From: David Robinson [REDACTED]
Sent: 27 November 2014 12:53
To: Simon Davis
Subject: Fw: Yapton Primary school

I relation to (part of) your second email, I am forwarding the following email trail with WSCC subsequent to a site meeting when, on behalf of my clients, I offered to provide a vehicular link through from the school to the development's new access so that a drop-off facility could be provided as suggested in the Yapton Neighbourhood Plan. However, as you will see, that was been rejected in favour of a facility to enable the school to provide improved staff parking and loading/unloading facilities.

From: Ian Patrick
Sent: 07 October 2014 16:38
To: Dominic Smith
Cc: Lyndsay Irvine; Pene Mather; Matthew Street; Julie Finn; Gregory Merrett
Subject: Yapton Primary school

DRAWING NO YAP/DR/1

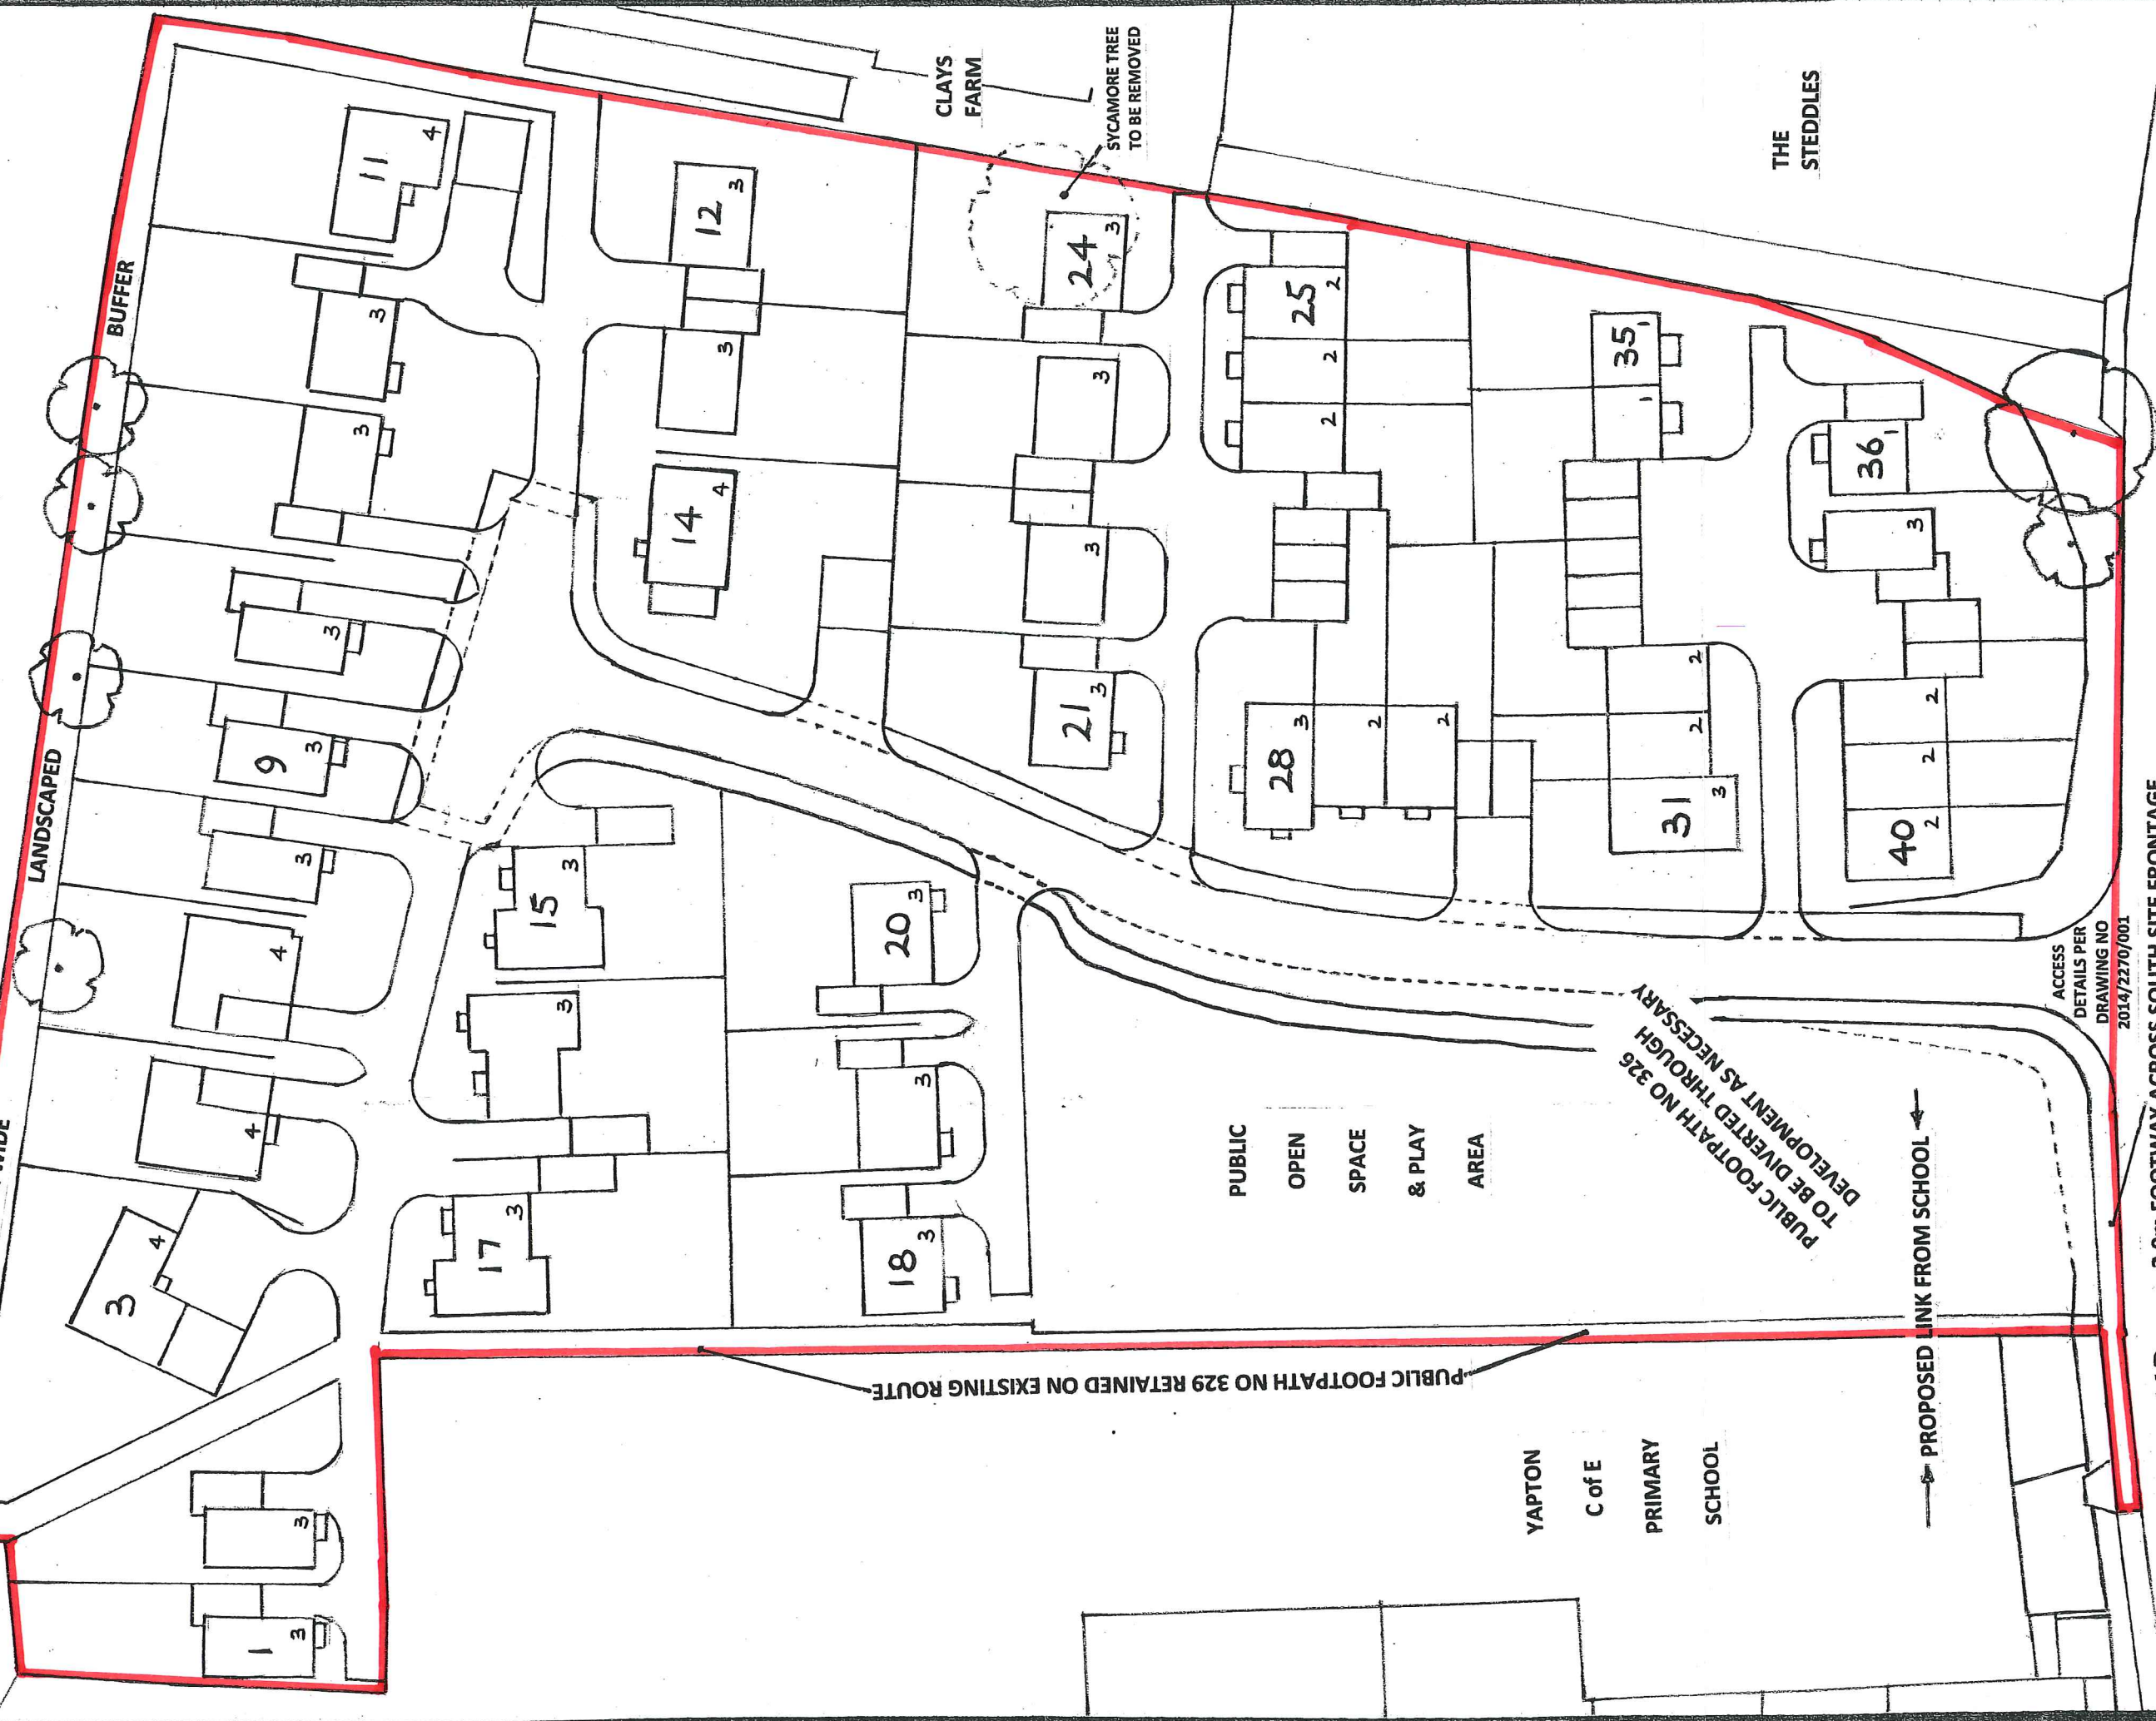
The proposed link shown on the indicative layout is intended to be for this facility, plus a pedestrian link from the development to the school. However, so far as my clients are concerned, they are relaxed about how the link is to be used and will agree to whichever facility you and WSCC require. I hope that explains why the notation on the plan is not specific about the use to which the link will be put.

Firstly, as I suspected, which is why it's so important to include schools in early dialogue, the developer proposed 'kiss n drop' area does not work for the school. There are potential school expansion opportunities ahead (poss around 2016) subject to many factors.

The school would prefer to reconsider the space proposed (by the developer) as a kiss n drop zone for improve staff parking and loading / unloading access. Whilst I would not normally support increasing parking (as it can act as an encouragement to drive) in this instance it would help to remove on street staff parking and ease issues at drop off and pick up time.

I suggest you coordinate a meeting with the HT, David Robinson (Developer), Pene and Lyndsay to agree a redesign of the proposed kiss and drop area.
